Our Ref: 2553/BC/KD/160911

16 September 2011

**Re: West Wallsend Colliery Continued Operations Project - Proposed Mine Plan Modifications**

Figure No: 1

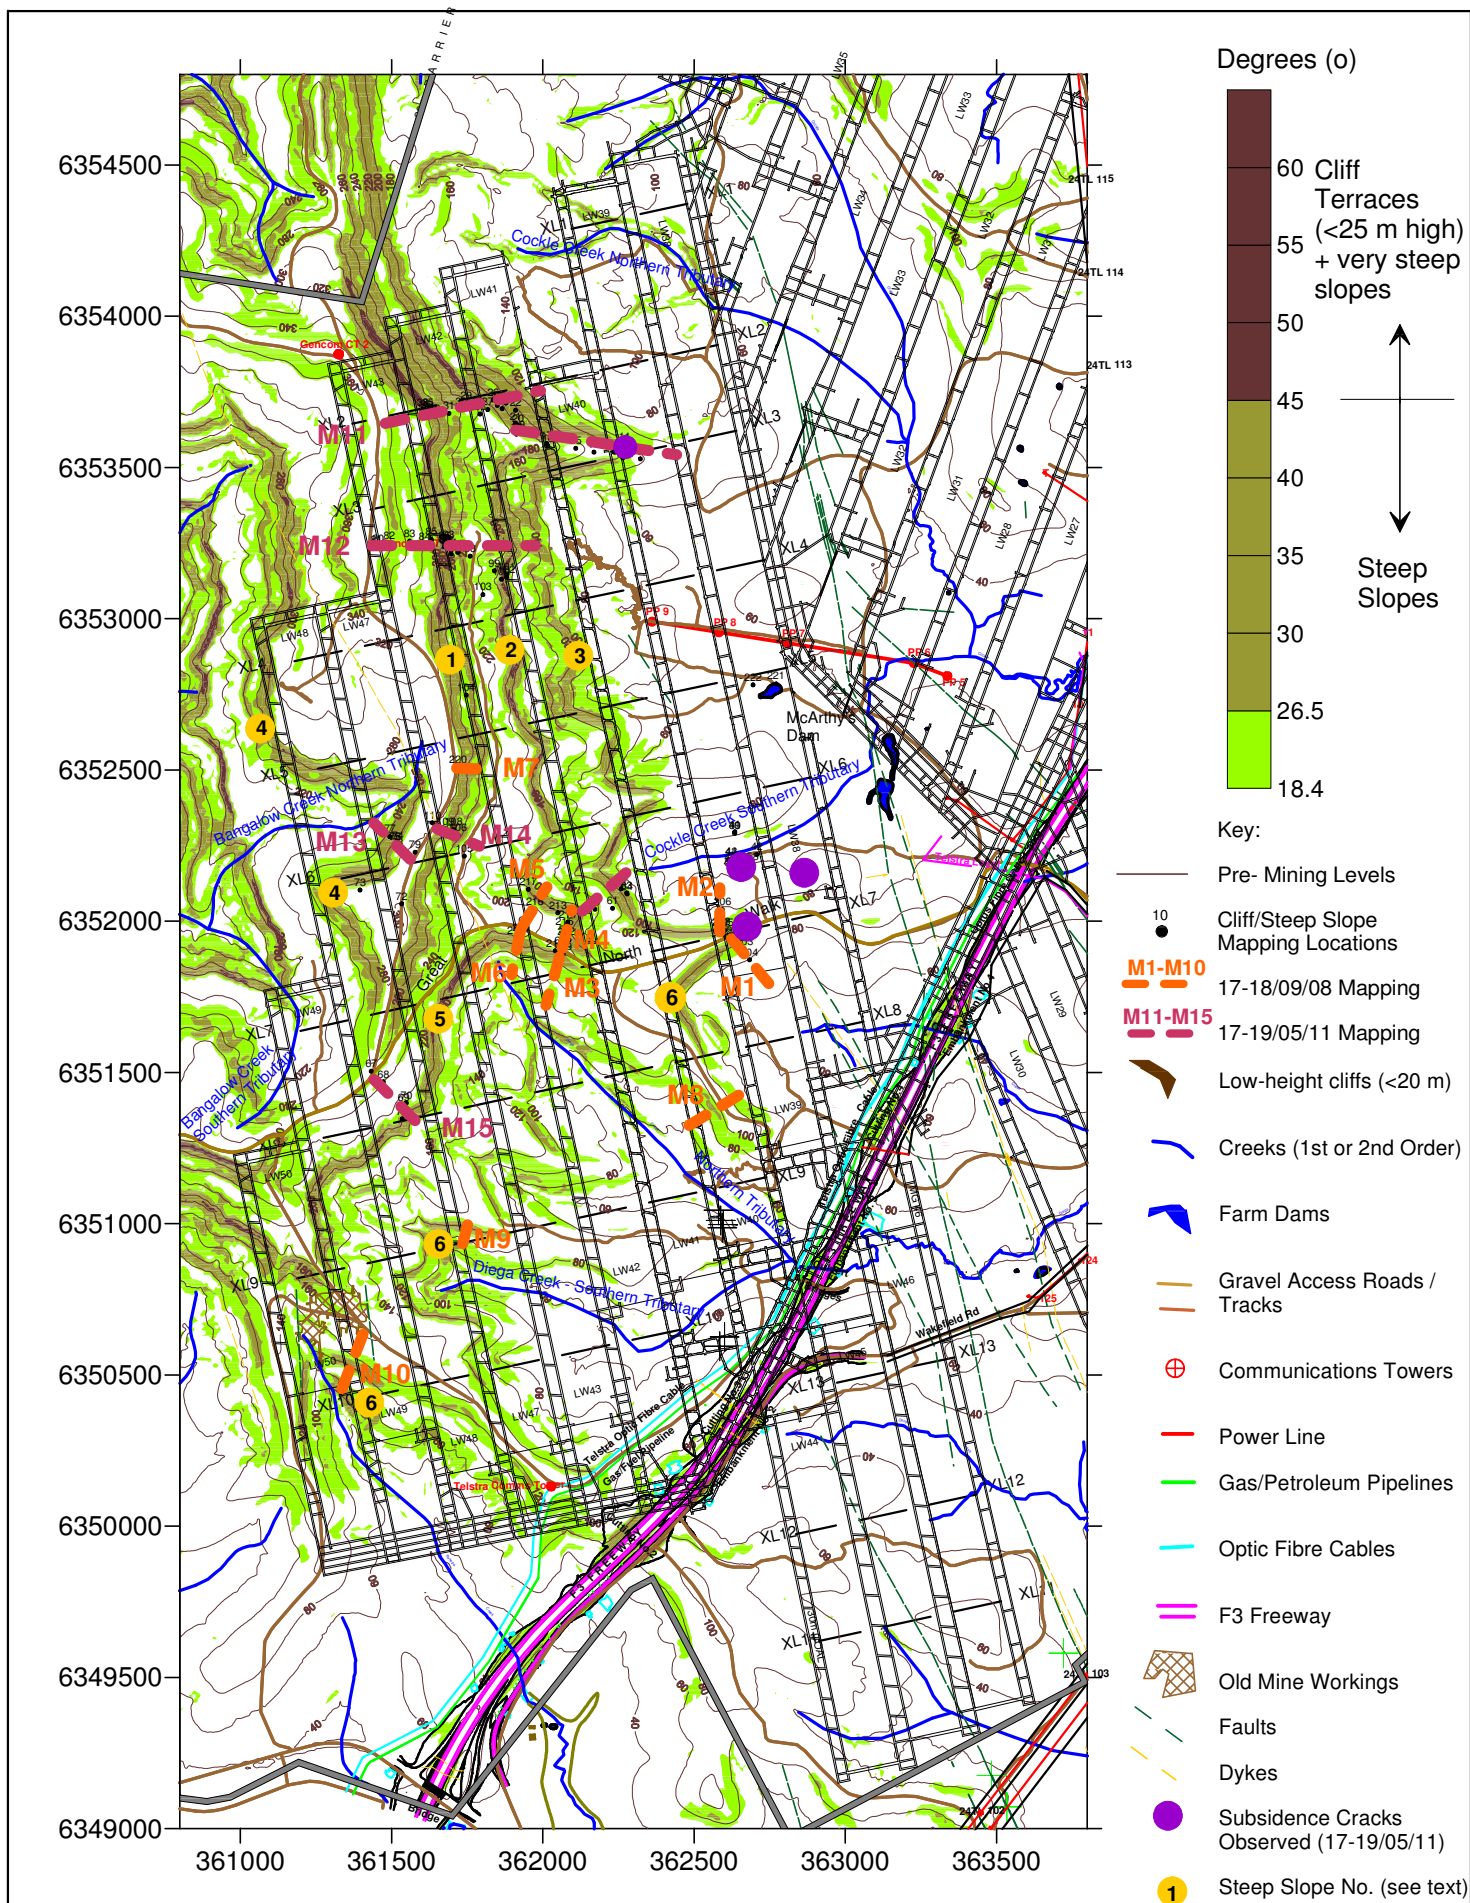
WWC have undertaken extensive further consultation with DTIRIS in regards to their concerns regarding steep slope issues. An additional subsidence assessment has been undertaken to identify the likely and credible worst case impact of the proposed operations on steep slopes and clifflines within the continued underground mining areas (refer to attached *Additional Mine Subsidence Impact Assessment of the Steep Slopes and Cliffs above the Proposed Longwall Panels LW38 to 50 at West Wallsend Colliery*, DgS 2011). One small section of cliffline above 20m in height has been identified and is shown on **Figure1**.

The further assessment identified a number of clifflines and steep slopes greater than 10 m within the continued underground mining area, refer to **Figure 1**. Of these, the only clifflines that may be publically visible are located in the northern extents of Longwalls 42 and 43.

There are additional clifflines greater than 10 metres located in the central portions of Longwalls 41 and 42 (refer to **Figure 1**). The assessment indicates that these clifflines are not publically visible. Additionally, a representative from DTIRIS (Ray Ramage) inspected these clifflines with WWC and confirmed he was comfortable that they are not publically visible. No mine plan modifications are proposed for these clifflines. It is considered the proposed management measures will adequately manage potential subsidence impacts on these clifflines.

**Proposed Additional
Mine Plan Modifications**

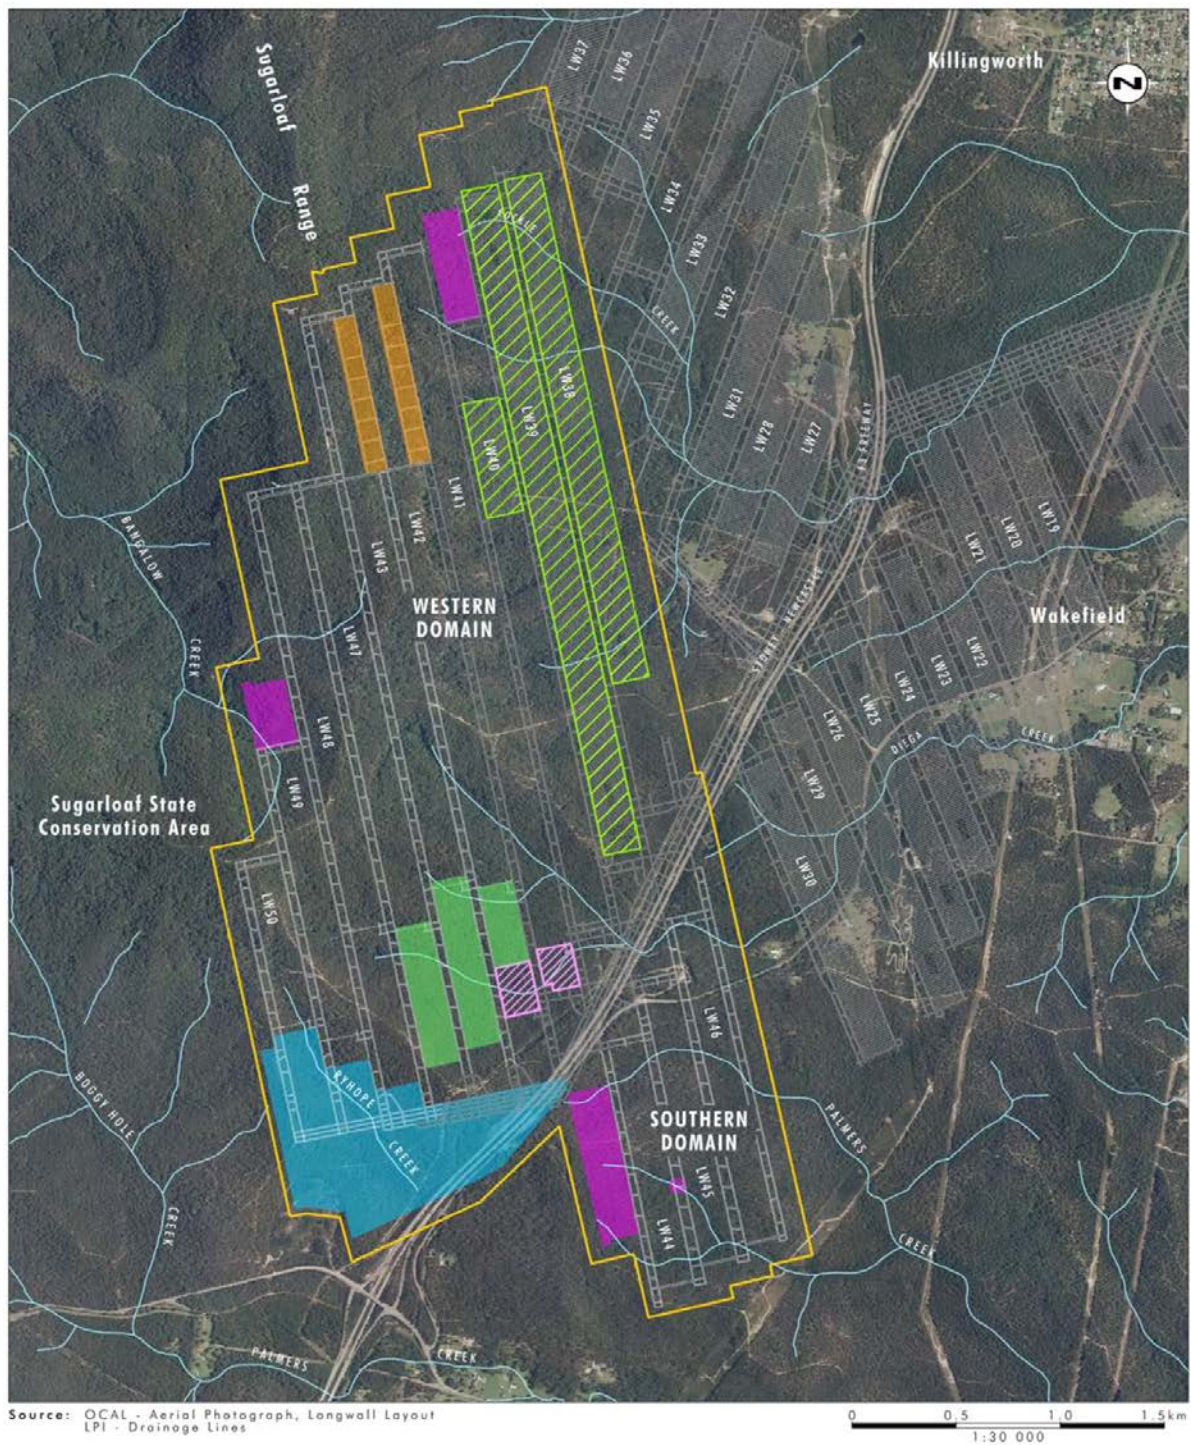
In light of the concerns raised by DTIRIS and the further subsidence assessment, WWC are proposing further modifications to the mine plan. The modification will result in reducing the longwall void width within Longwalls 42 and 43 (refer to **Figure 2**) to 115 metres. The reduced panel width will result in reducing the predicted subsidence impacts to the potentially visible clifflines from 'High' to 'Low'.

Following the proposed mine plan modifications, the cliffs and slopes within the northern extent of Longwalls 42 and 43 are predicted to be subsided by up to 0.2 m. The tilts are estimated to range from 4 to 20 mm/m and the tensile strains likely to be up to 4 mm/m. Surface cracking of 40 mm to 200 mm is now predicted within the upper slopes.

The decision to reduce the panel void widths of Longwalls 42 and 43 from approximately 178 to 115 metres in parts of Longwalls 42 and 43 was based on maximising resource recovery and minimising potential subsidence impacts on the identified clifflines. The proposed modifications will sterilise an additional 0.5Mt of coal resource at WWC. The proposed mine plan modifications will enable appropriate subsidence management plans to be implemented without significant risk to public safety, cliffline aesthetics or damage to existing infrastructure. Ongoing monitoring and review of the effectiveness of the management process will be undertaken as mining progresses.
